Town of Addison

Summary of Engineering Review Comments

Date: August 23, 2019
 Plan Review : Civil Review 1
 Received: July 30, 2019
 Plan Date: July 25, 2019
 Development: Galaxy FBO

Town Project #:19-09D

SHEET NUMBER
C03.02

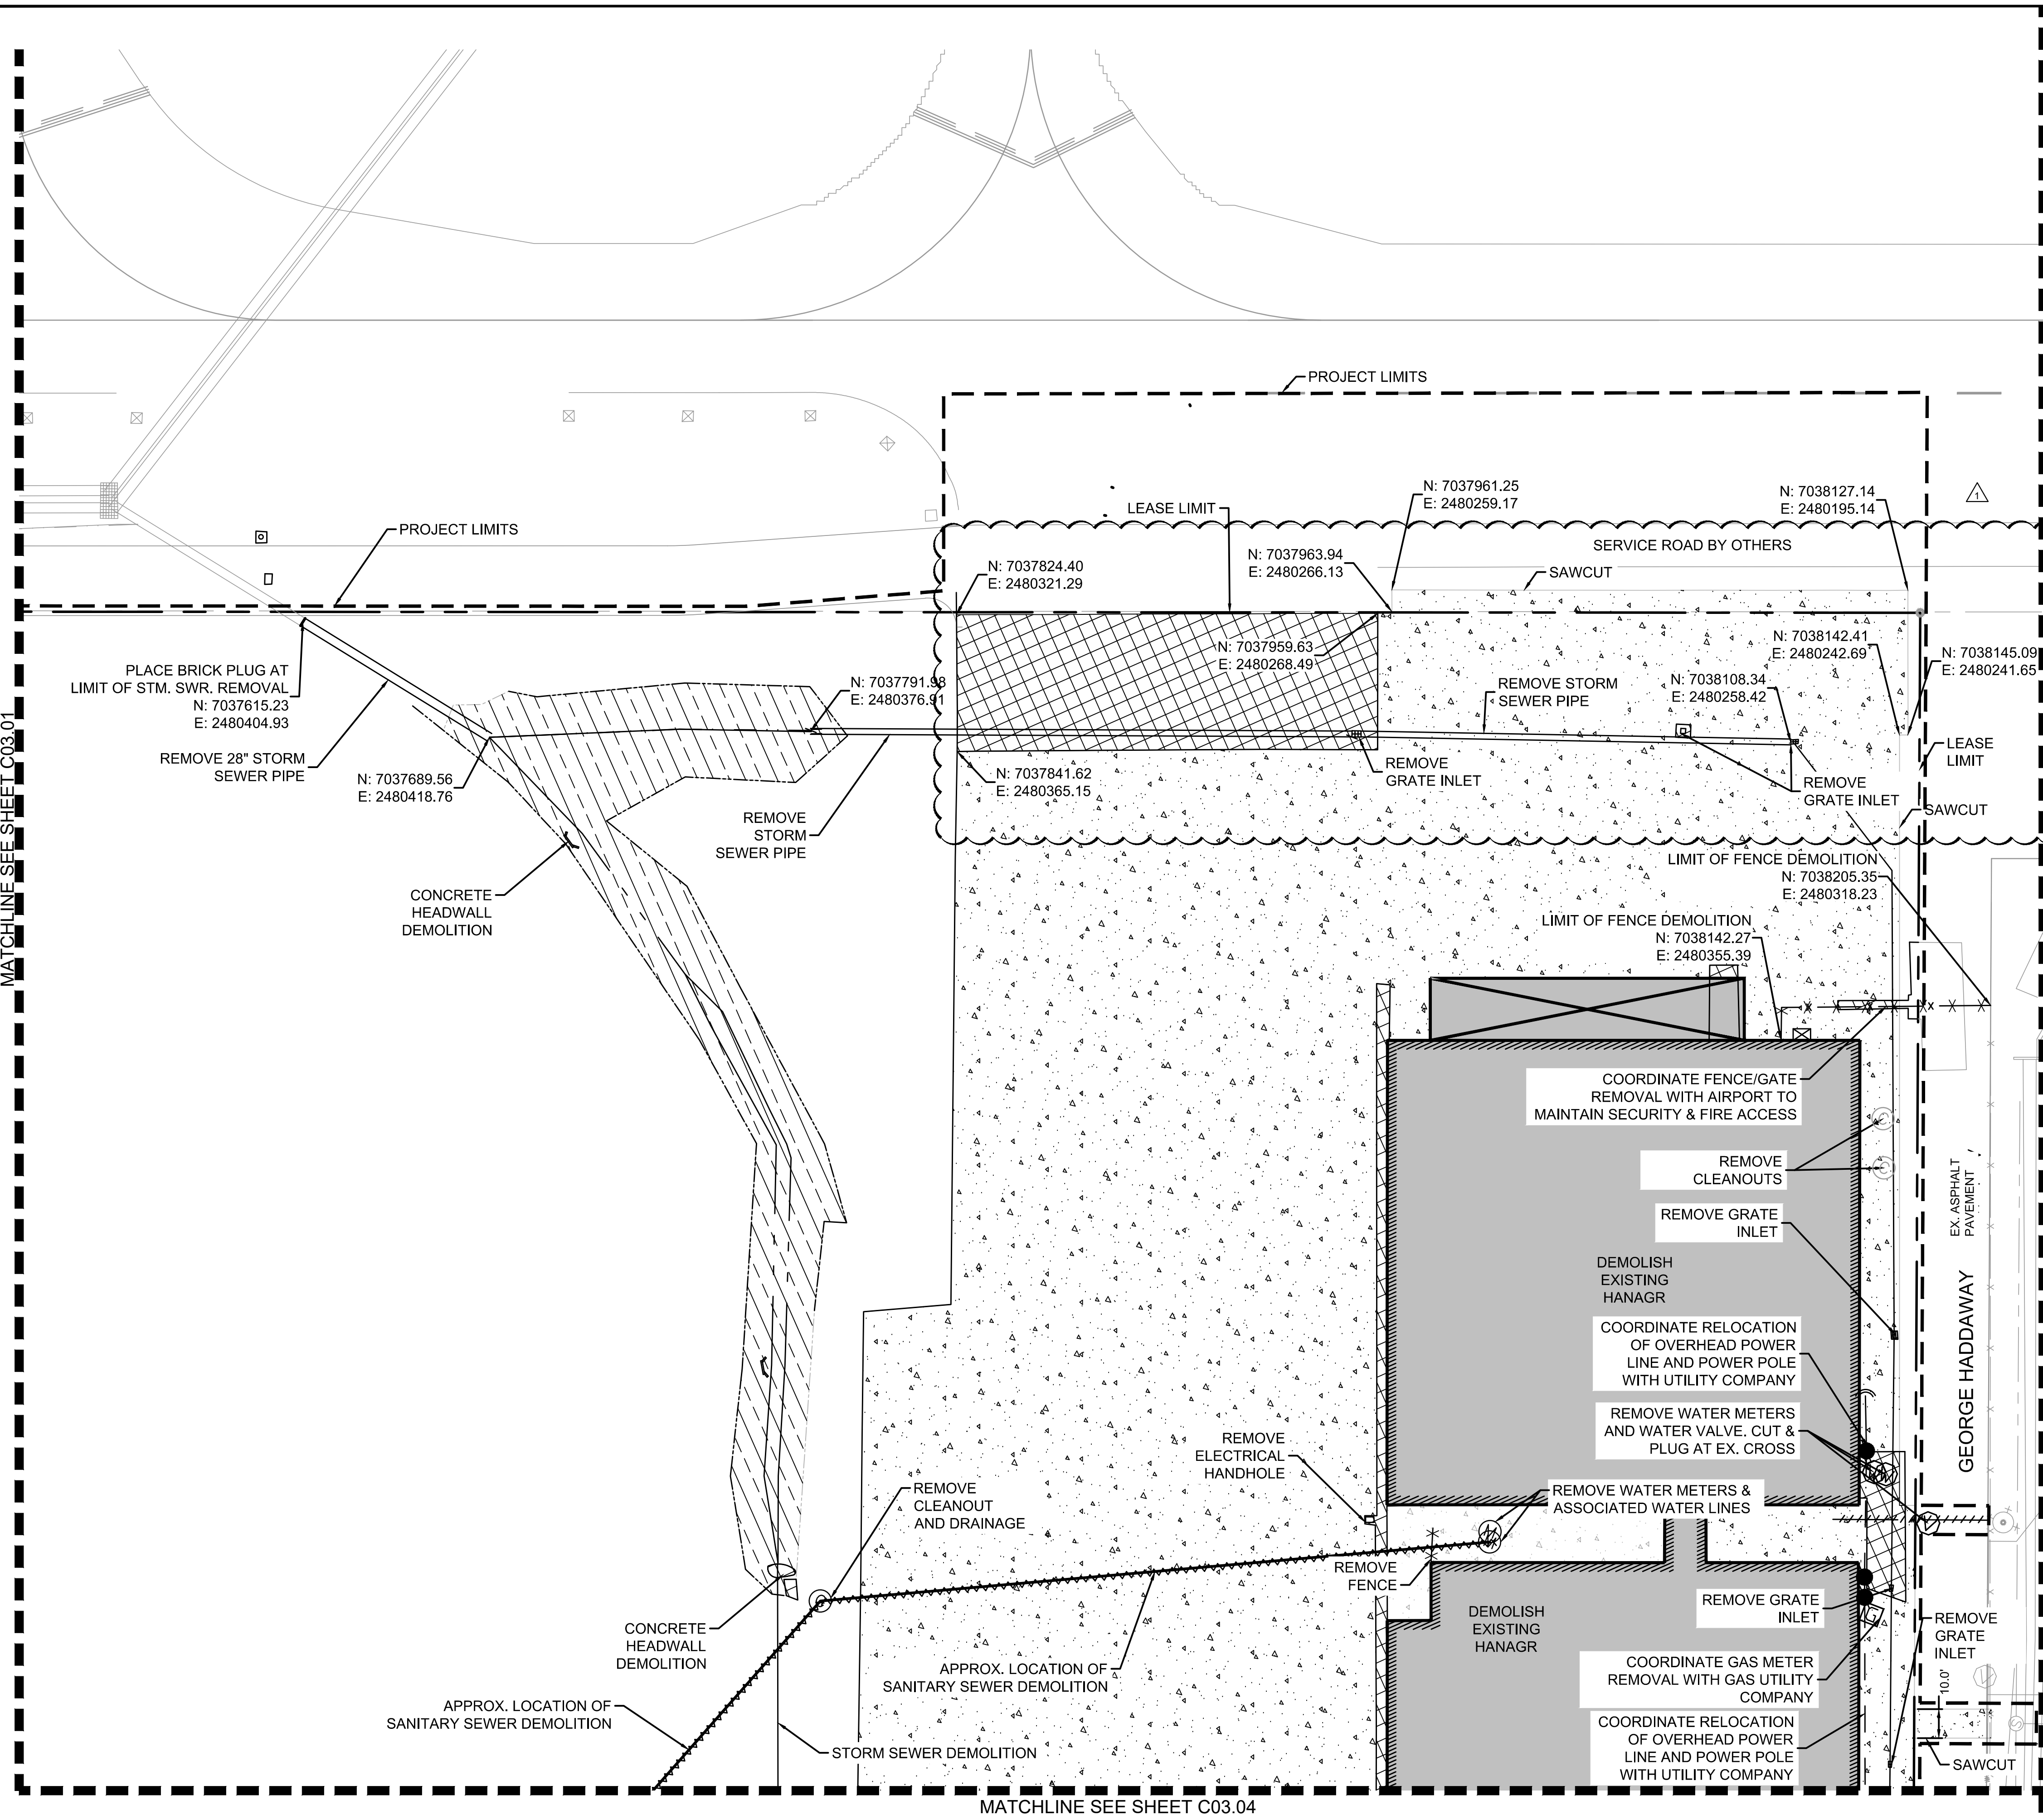
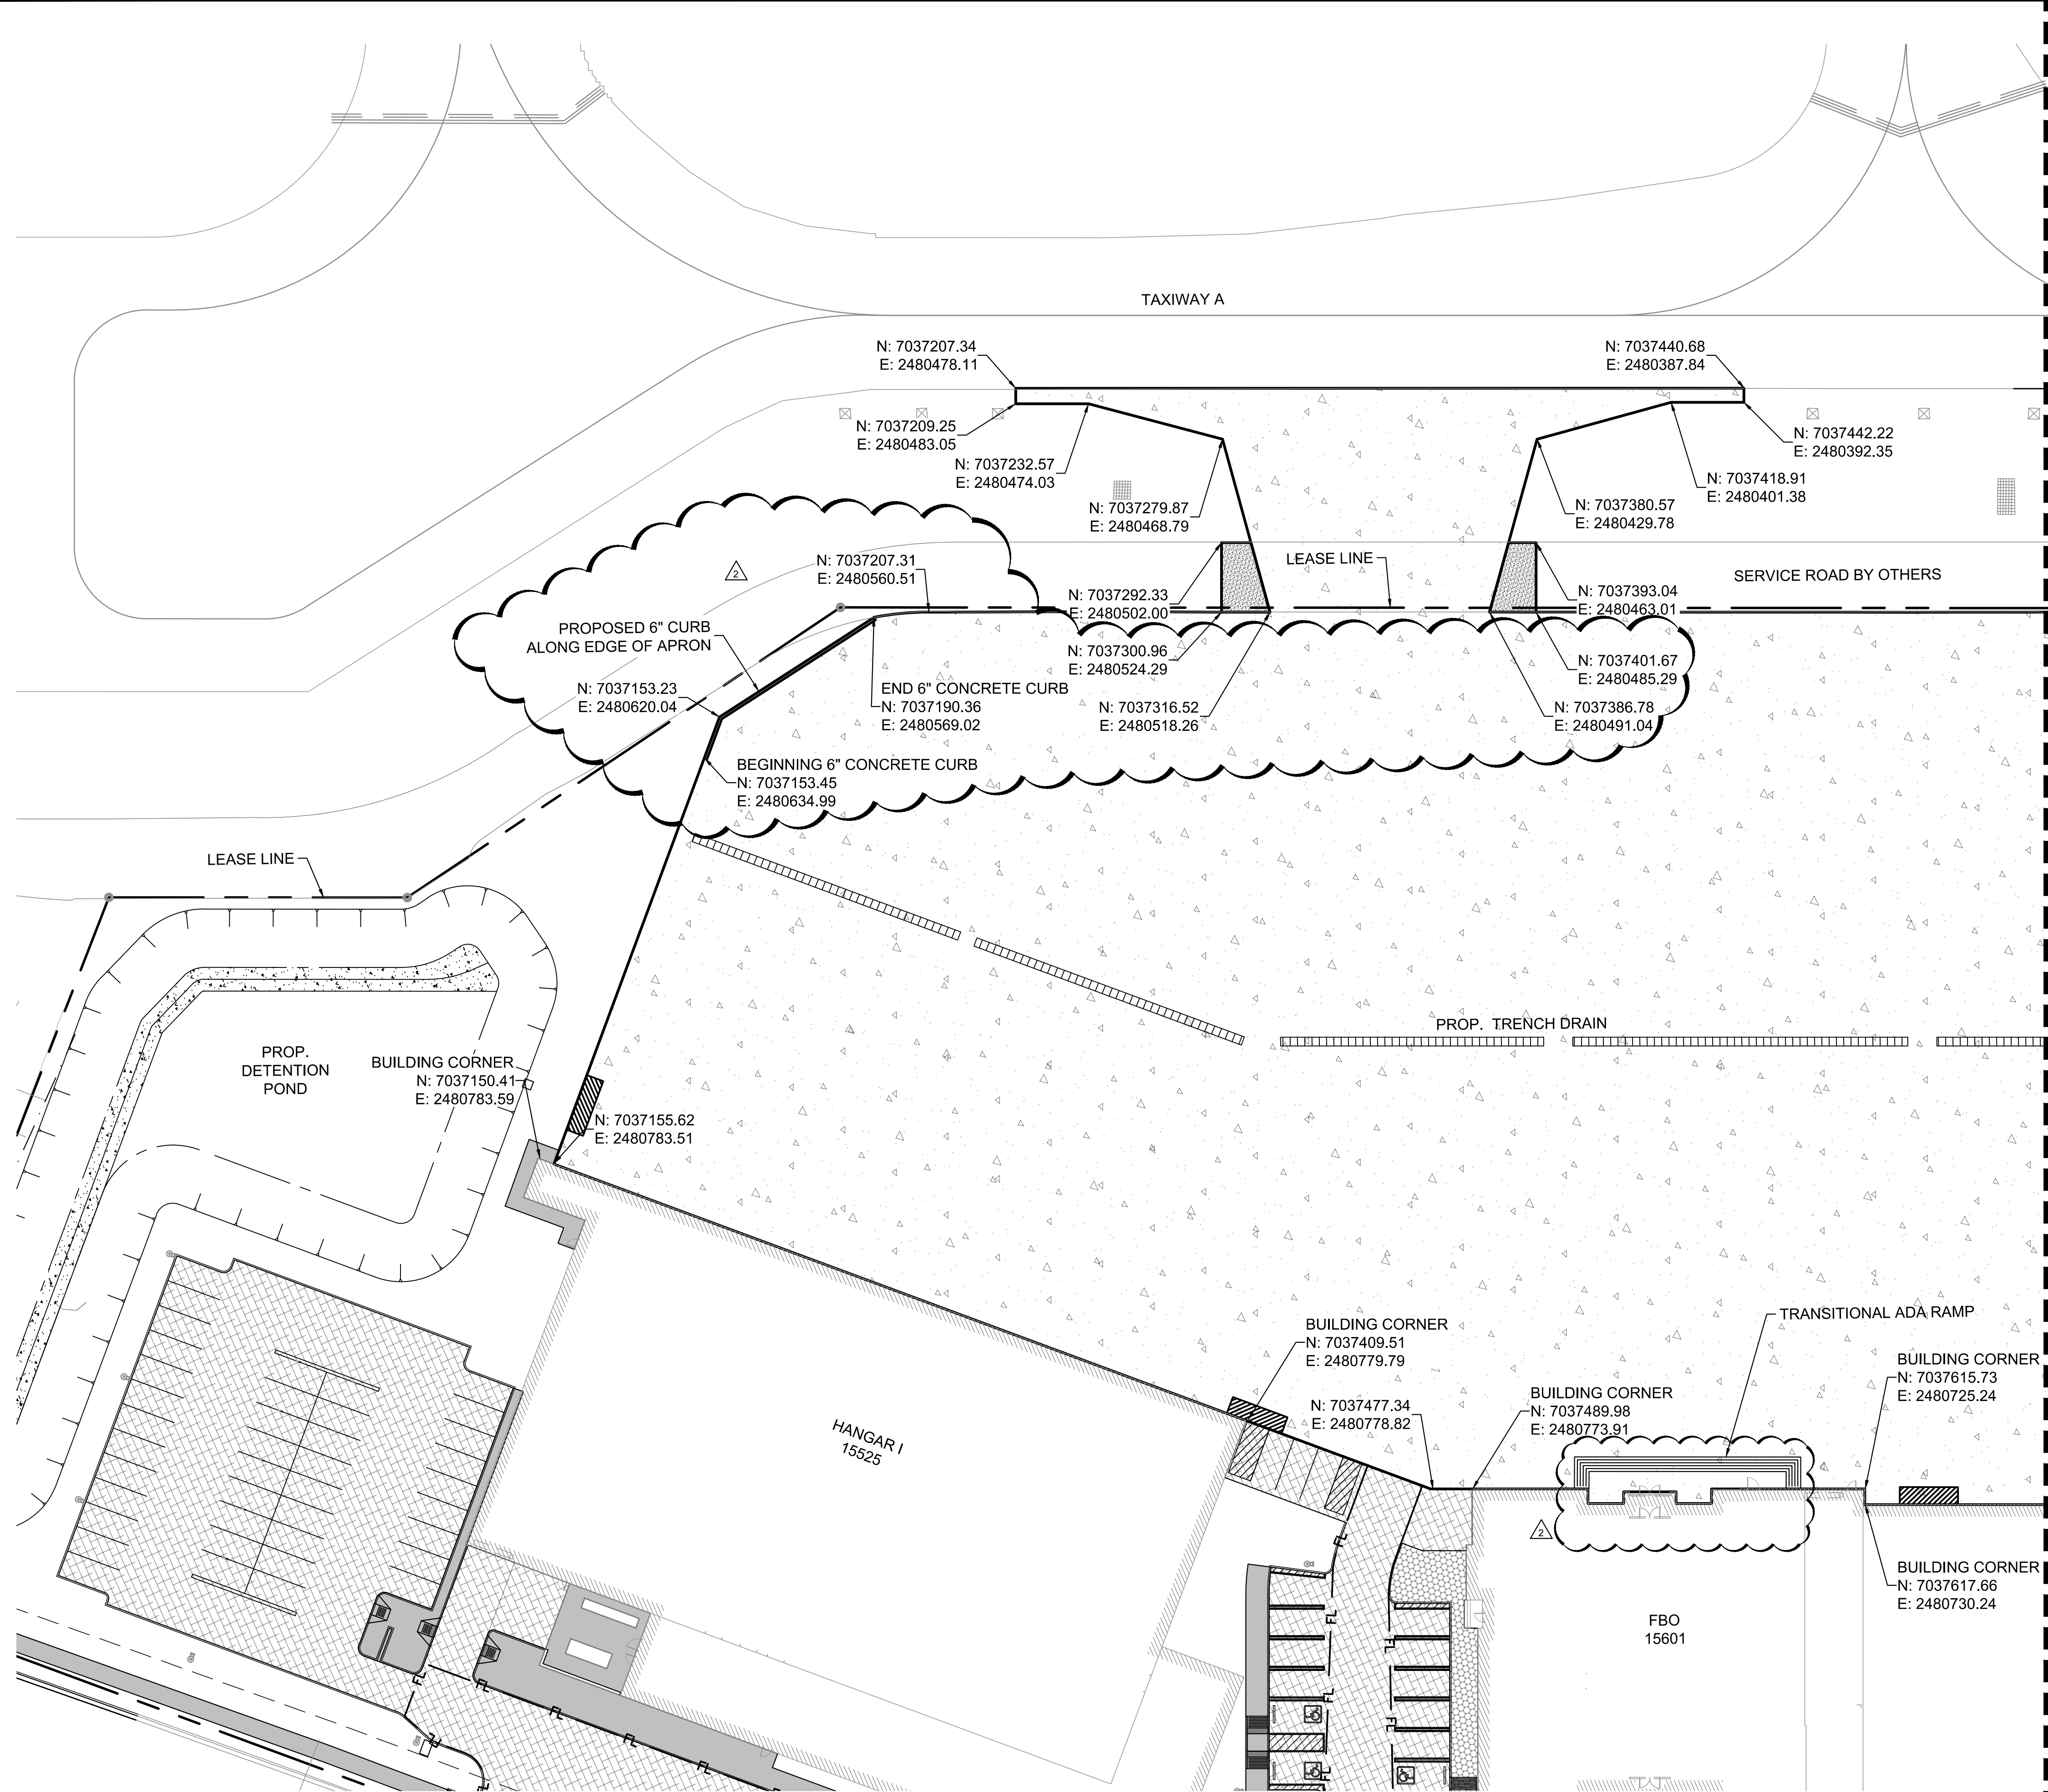
C01.00 & 03.01	Extend project limits to encompass ALL paving/grading/drainage/utility work.	DISAGREE	THESE REFERENCED LINES INDICATE THE LEASE LIMITS. PLEASE SEE UPDATED CALLOUTS FOR CLARITY.
C01.01	Does the existing double 24" RCP have SET's or headwalls?	AGREE	SET's
C01.02 & 01.03	Check your viewports - plan view doesn't line up with labeling arrows.	AGREE	
C02.01 & 02.02	Include CI protection on Addison Rd inlets.	AGREE	
C02.03	Revise sheet number	AGREE	
C02.03	Use TOA standard details where applicable.	AGREE	
C03.01	Note to remove existing landscaping as applicable.	AGREE	
C03.01 & 11.02	Where is the OH being relocated? Show.	AGREE	SEE SHEET C18.01 FOR PROPOSED RELOCATION
C03.01	Demo sidewalk to property line & connect back to ex.	AGREE	
C03.02	Coordinate fence/gate removal with airport to maintain security & fire access.	AGREE	
C03.02	Show ex. Sanitary service lines & cleanouts	DISAGREE	ALL KNOWN UTILITIES ARE SHOWN

C03.02	Water should be cut & plugged at the cross.	AGREE	
C03.03 & 03.04	Connect ex. Water line crossing Addison Rd to proposed line, demo ex line beyond extension point.	AGREE	
C03.04	Show all existing drainage pipes across the site - coordinate with Dave Wilde to get records.	AGREE	DRAINAGE COMING FROM THE FUEL FARM HAS BEEN ADDED
C03.04	Remove tee on northern end of demo'd water line	AGREE
